**WELWYN HATFIELD BOROUGH COUNCIL  
ASSISTANT DIRECTOR (PLANNING)**

**DELEGATED APPLICATION**

**Application No:** 6/2022/2788/FULL  
**Location:** 64 Walker Grove Hatfield AL10 9PL  
**Proposal:** Change of use from Dwelling house (Class C3) to Children's home (Class C2)  
**Officer:** Ms Ashley Ransome

**Recommendation:** Refused

<b>DRAWN:</b> MFJ	<b>DATE:</b> 20/01/2023	
<b>SHEET SIZE:</b> A3	<b>SCALE:</b> 1:100	
<b>PROJECT NO:</b> 64/2023	<b>DRAWING NO:</b> PD 01	<b>REV:</b>

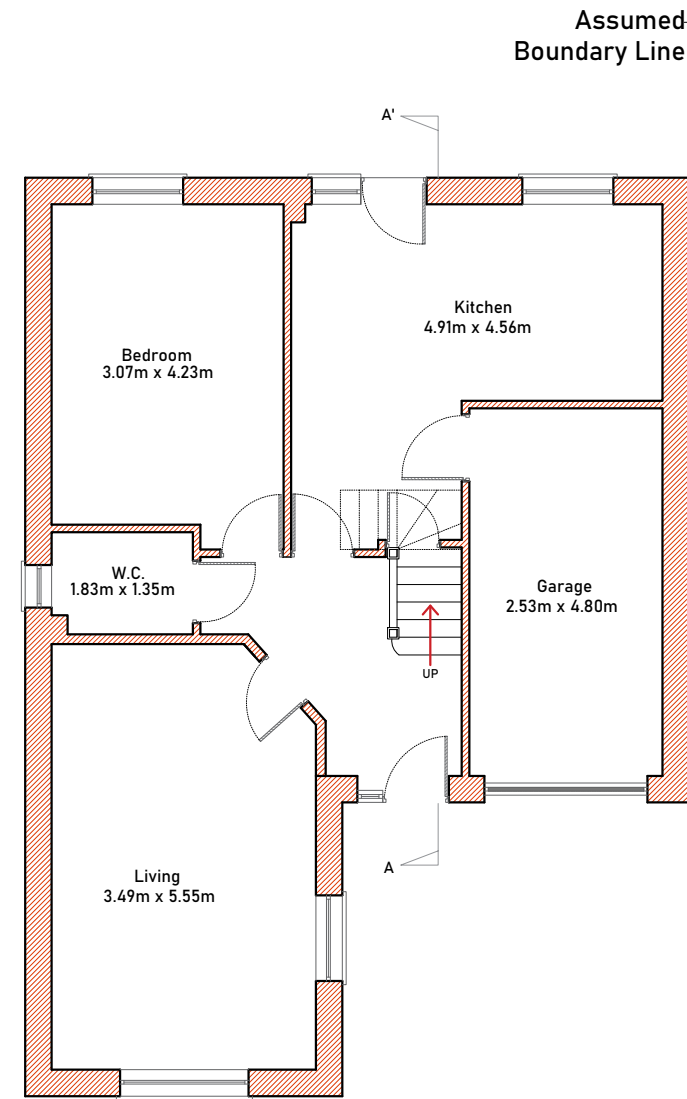
Firstly, the garage does not realistically provide a useable parking space for most vehicles. This is based on the Interim Policy for Garage Sizes as set out within the Interim Policy for Car Parking Standards and Garage Sizes whereby it states that '... domestic garages have a genuine ability to be used for the intended purpose by being at least 6 metres long by 3 metres wide and sufficiently tall to accommodate modern cars'. The existing garage measures approximately 4.8 metres by 2.5 metres which is a significant shortfall.

While the garage at the application site might be suitable to park a small car, it would be too short and narrow to accommodate most modern cars given the space needed for a person to enter and exit the vehicle. A car parked on the driveway in front of the garage would also prevent the use of the garage for parking. As a result, drivers of most vehicles would choose to park on the road near to the application site.
